Our Ref: **BR/154/12/**
Your Ref:

Application for Planning Permission for Works or Extension to a Dwelling

Development Extension to rear of property
Location 93 Orchard Way Bognor Regis

Dwg No: KS/NSS/01

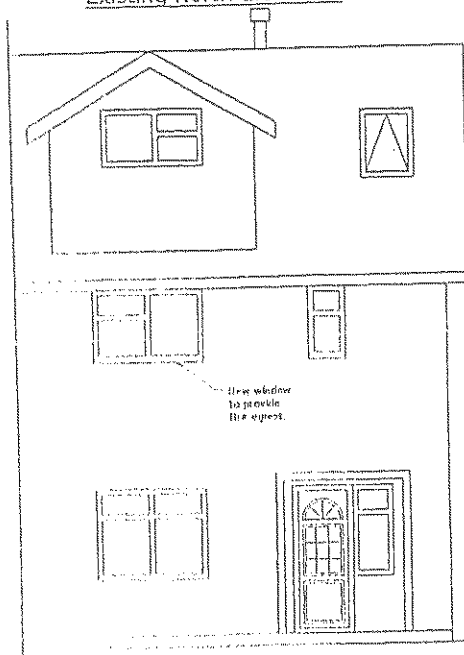
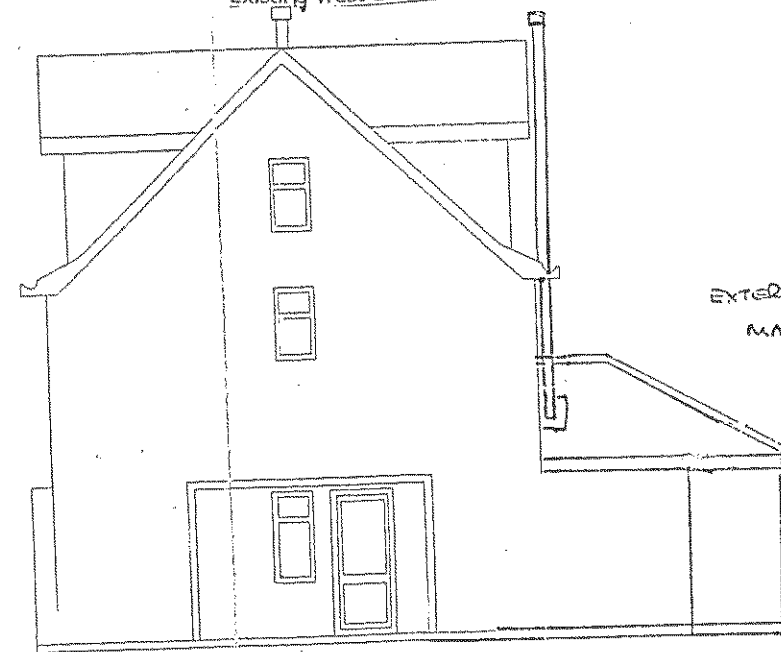
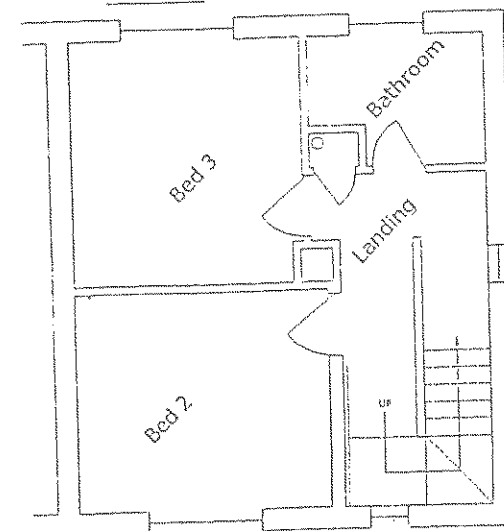
Please provide 1 electronic or 3 paper copies of amended existing west and south floor plans and elevations at a scale of 1:50, as the plans submitted do not coincide, in accordance with the guidance notes available on our website detailed below (click on National List).

Proposed North Elevation

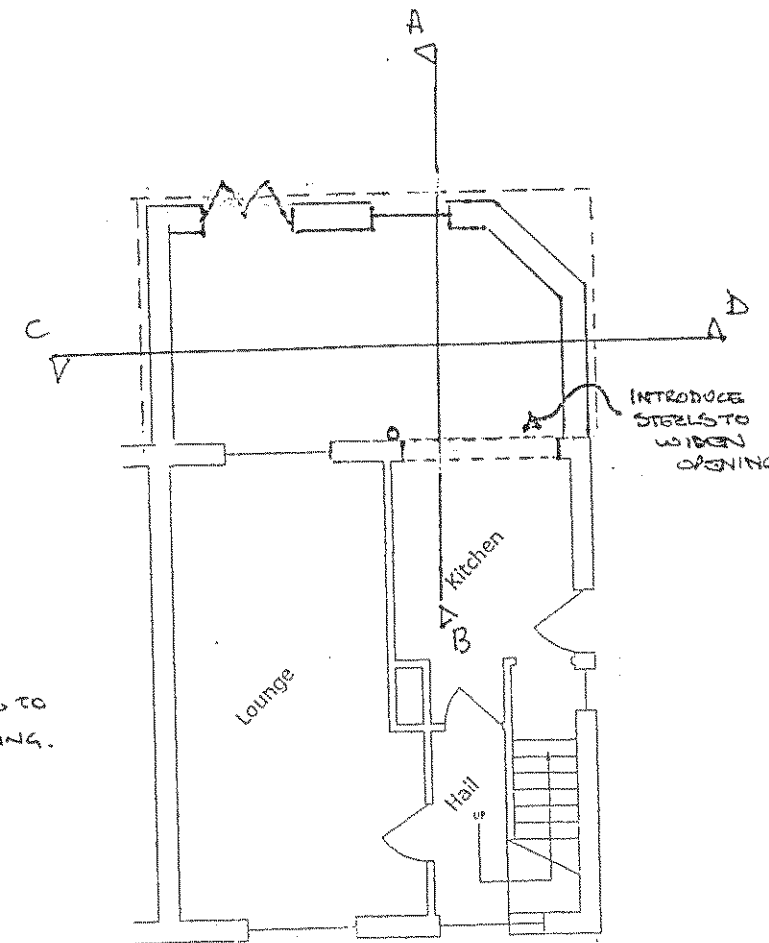
Please provide 1 electronic or 3 paper copies of revised proposed north floor plans and elevations in accordance with the guidance notes available on our website detailed below (click on National List). You have indicated on the North elevation that there is to be a proposed Velux however, you have omitted to show this on a floor plan or include this in your description. If the velux forms part of the application then please amend the description and include a floor plan, if it not then please remove it from the North elevation.
